DPIE reference: SSD 9383

**SSD 9383: Site 2A/2B DRP – Public Domain response**

Thank you for sending the revised landscaping and public domain plan for site 2A and 2B which was received by Sydney Olympic Park Authority (SOPA) on 12 July 2019.

VIEW 01: SITE 2A FORECOURT

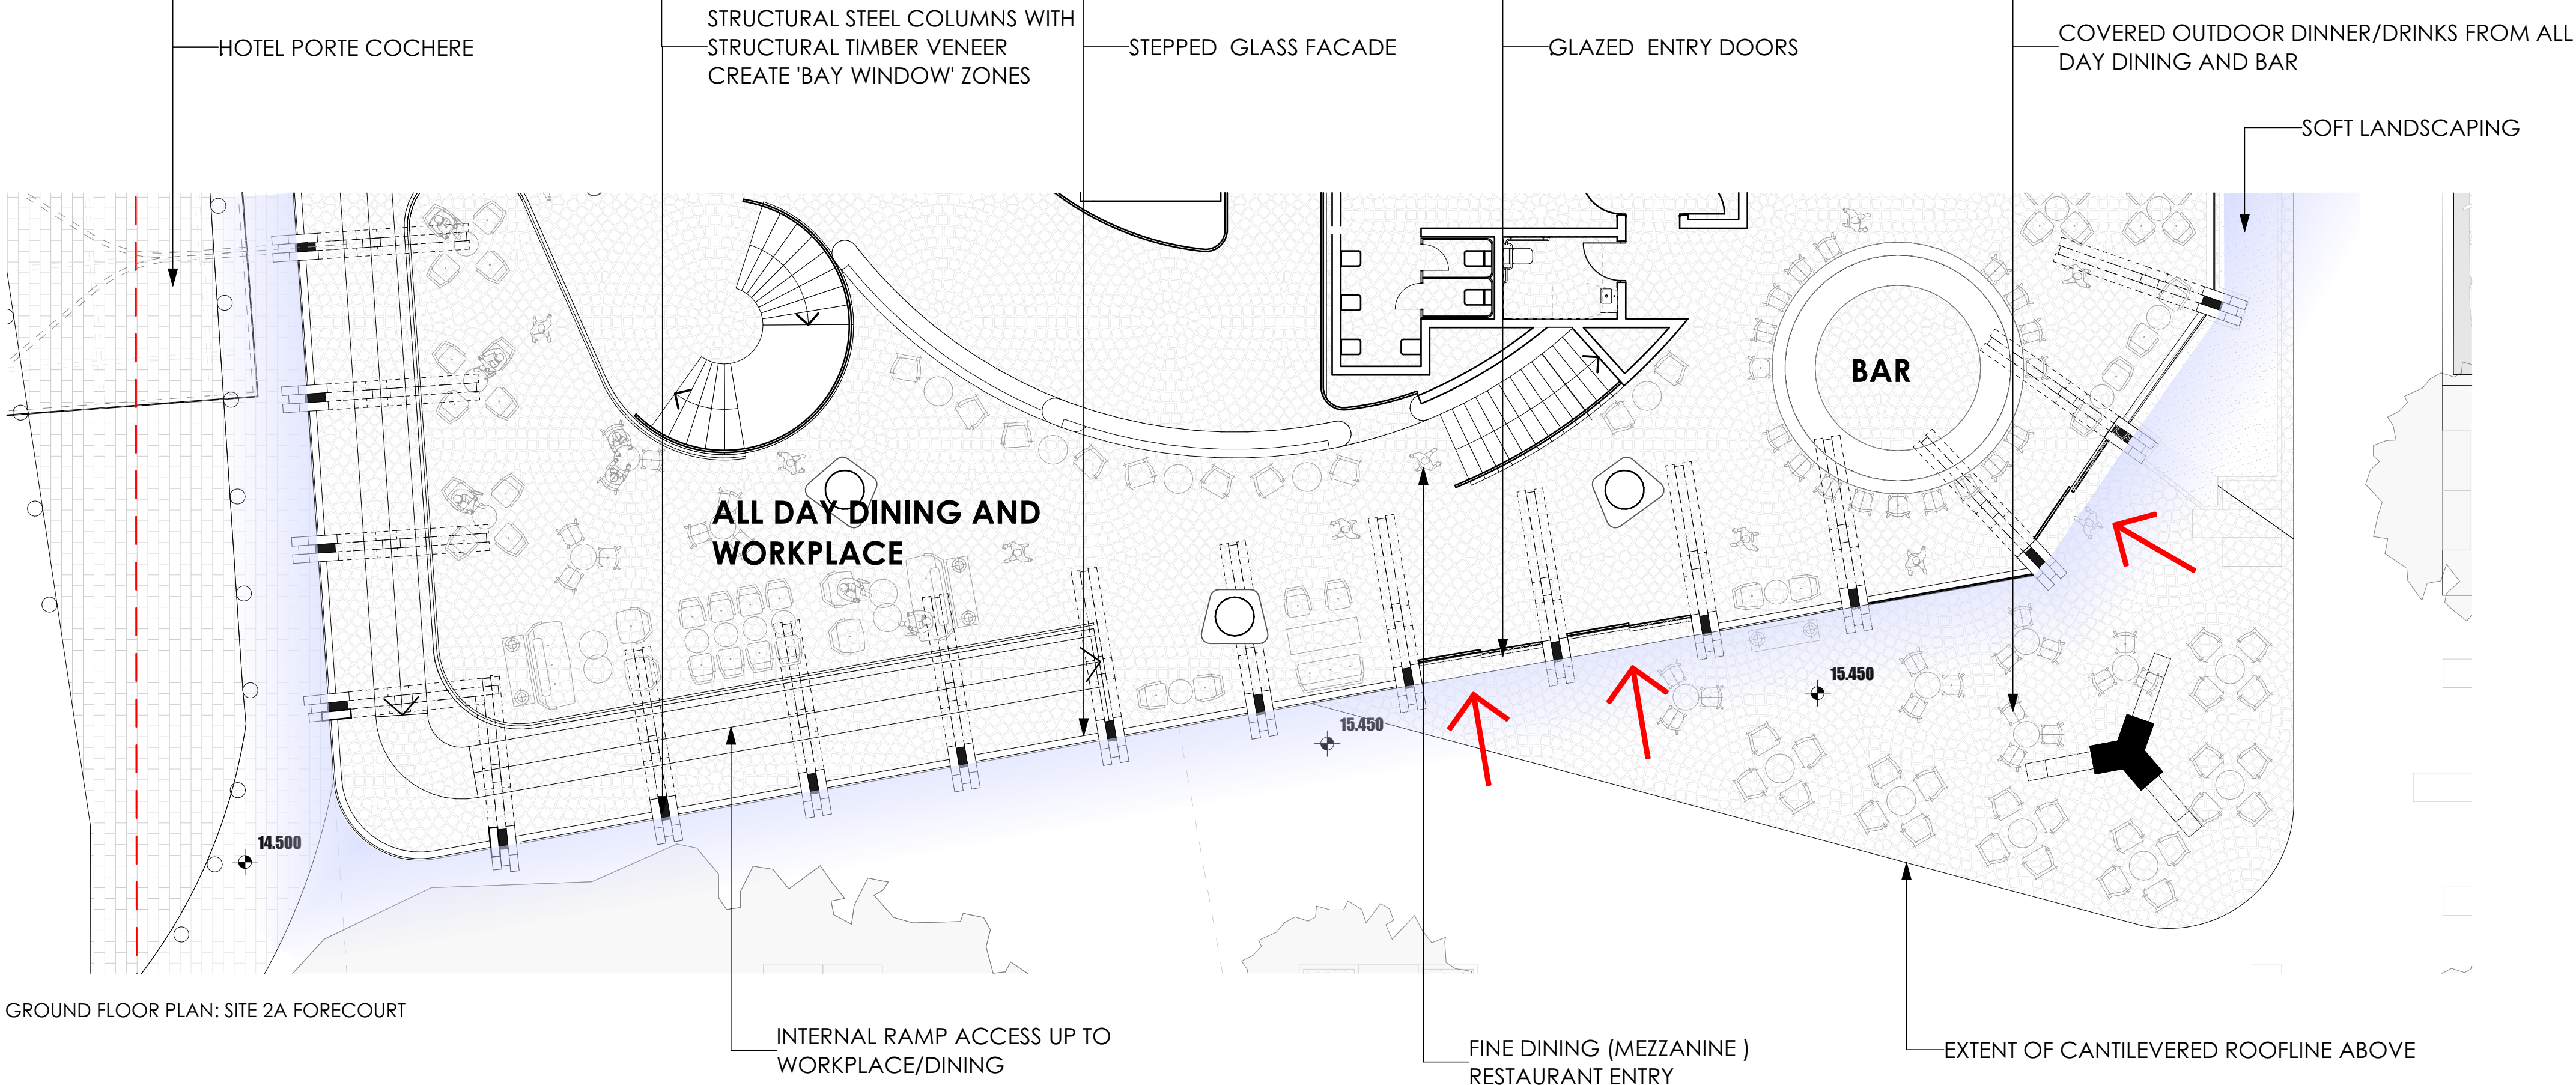
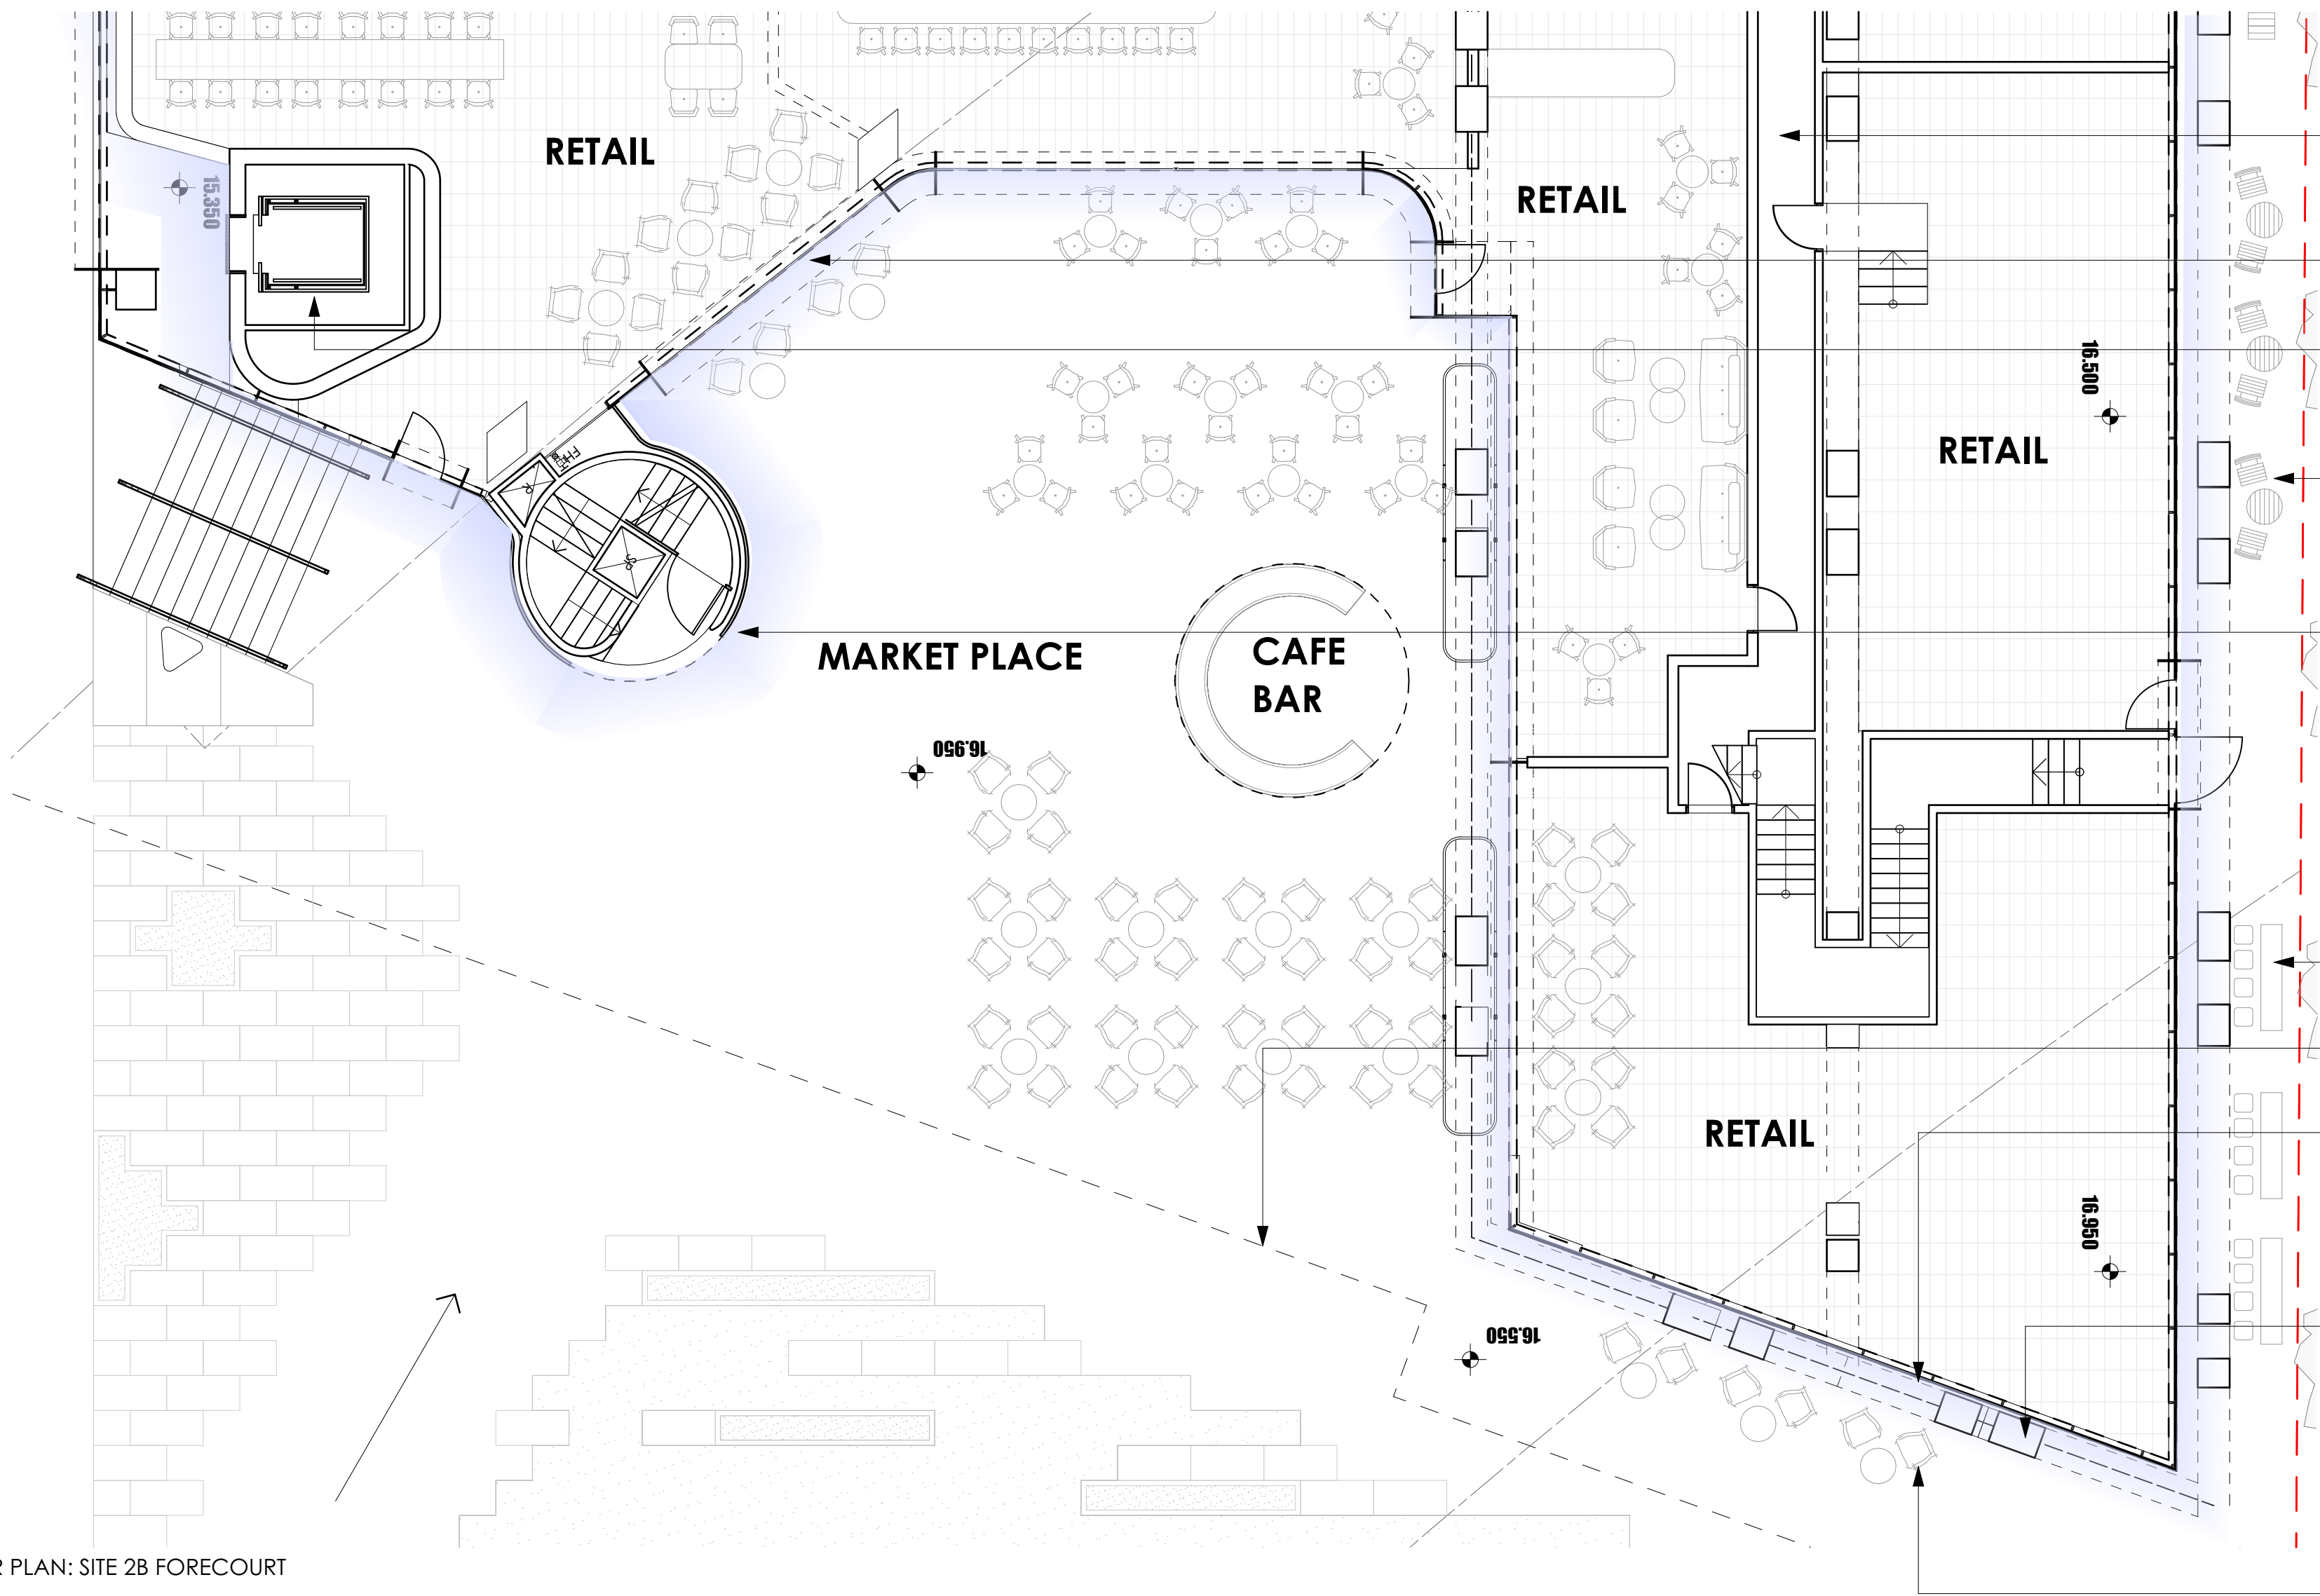
Of particular concern is the extent of hard landscaping to the front of the buildings and the distinct lack of soft scaping, green cover and plantings. Site 2A/2B is a key site within the town centre of Sydney Olympic Park, opposite Jacaranda Square, in close proximity to the station and on the main Australia Avenue axis road. With regards to the ground plane, it forms an important transition site between the town centre and the emerging mixed commercial and residential Parkview neighbourhood. Accordingly, the treatment to the ground floor plane, public domain and landscaping is of paramount importance to the suitable and appropriate development of the site and how the site is appropriately imbedded into the emerging urban fabric of the town centre.

DRP Comments	Arcadia Response	SOPA Comments
<p><i>Appropriate locations for turf and soft landscaping to maximise its use and minimise risk of failure from overshadowing and foot traffic</i></p>	<p><i>Based on the advice of the DRP and further shadow analysis the areas of turf previous located in the 2A forecourt have been removed to create an urban plaza and stepped terrain landscape framing the existing Ficus. Additional planting has been introduced along Dawn Fraser East to soften the urban footprint providing areas for potential rain gardens.</i></p>	<p>The removal of shaded turf areas is noted given the heavy shading from the Morton Bay Fig and proposed built forms; however, there are opportunities for under storey plantings of micro-climate appropriate plants. Additional planting and potential rain gardens integrated with street trees in Dawn Fraser extension is supported and should be further explored.</p> <p>There is a distinct lack of urban green cover in this iteration of the proposal. The inclusion of urban planting should not be dismissed on the basis that the site sits within the shade; shade appropriate planting should be considered and integrated into the design of the proposal.</p> <p>SOPA welcomes the provision of planting along Dawn Fraser East; however, further planting and softscaping should be provided in addition to this.</p>

VIEW 04: SITE 2B DAWN FRASER AVE

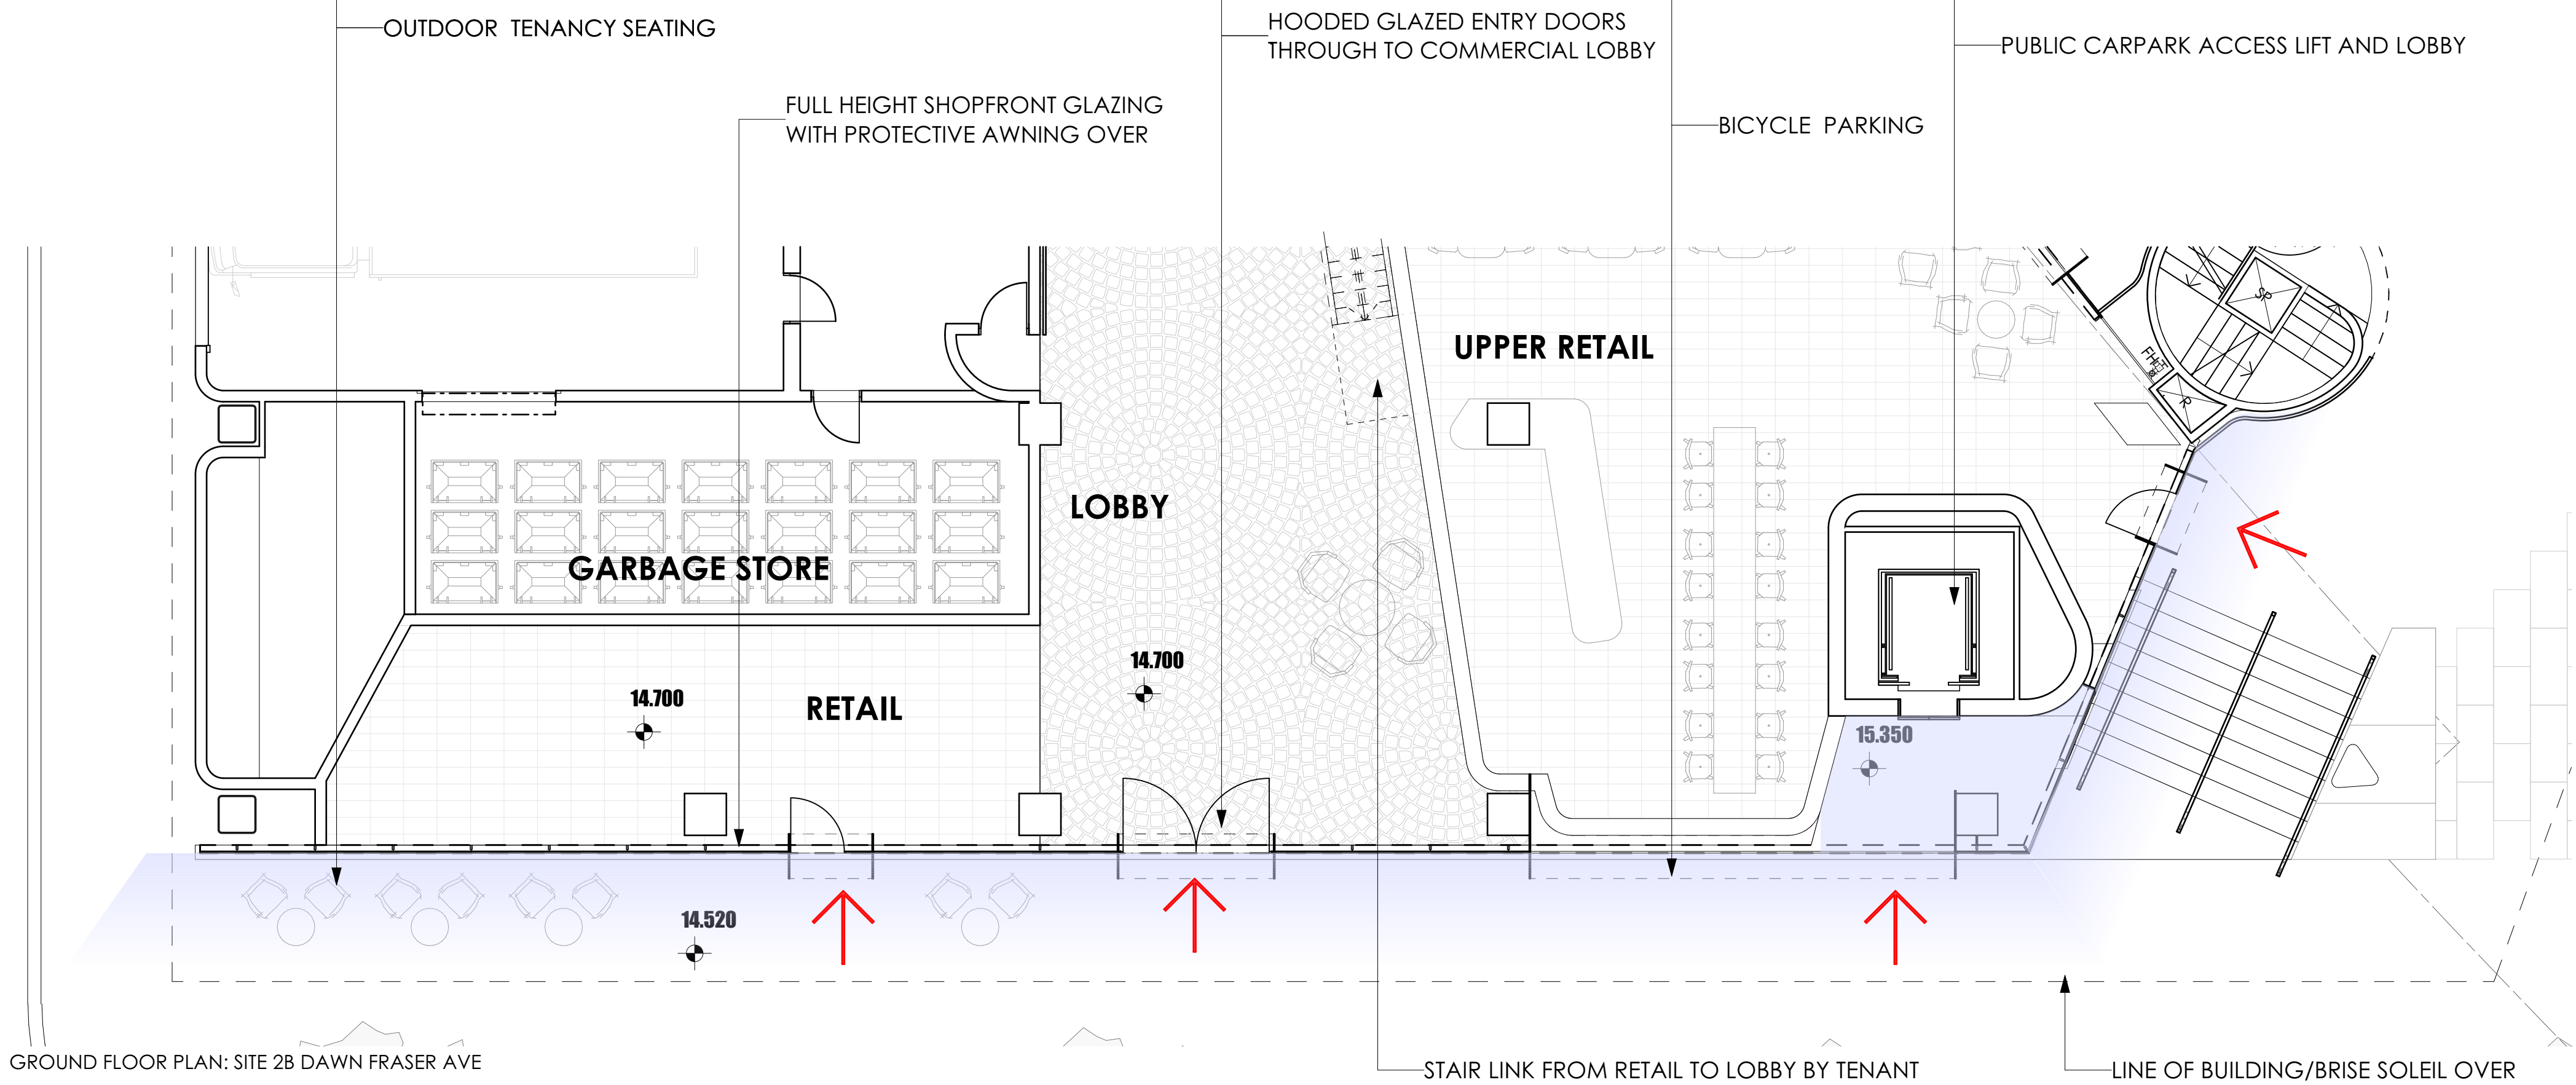
<i>The response to the forecourt of the market hall at Site 2B, so as to reduce clutter and barriers to movement</i>	<i>The 2B forecourt has been enhanced to allow porous circulation throughout the plaza and urban grove and allows for wide and accessible Connections via key desire lines into and from the 2B tower.</i>	<p>It appears that the approach to the ground floor of building 2B has been amended with the inversion of the thermal line of the building to create an external atrium space. This constitutes a major modification to the design of the proposal and requires further review by SOPA prior to the submission of the SSD.</p> <p>Nevertheless, activation of the space to the front of building 2B is key and proposals must ensure that there are opportunities for activation to spill out into the public domain. The current iteration of the proposal does not provide examples of how this could be achieved; in particular the arboretum to the front of building 2B could be perceived to be a dark and uninviting space. Further details are thus required as to illustrate how the space would be read as a porous and active plaza.</p> <p>In addition, a portion of the seating needs to provide backrests and side arm support to meet SOPA's Access Guidelines. Whilst elements of informal seating is not discouraged, appropriate seating which meets the needs of all users should be provided and integrated into the overall landscaping approach.</p>
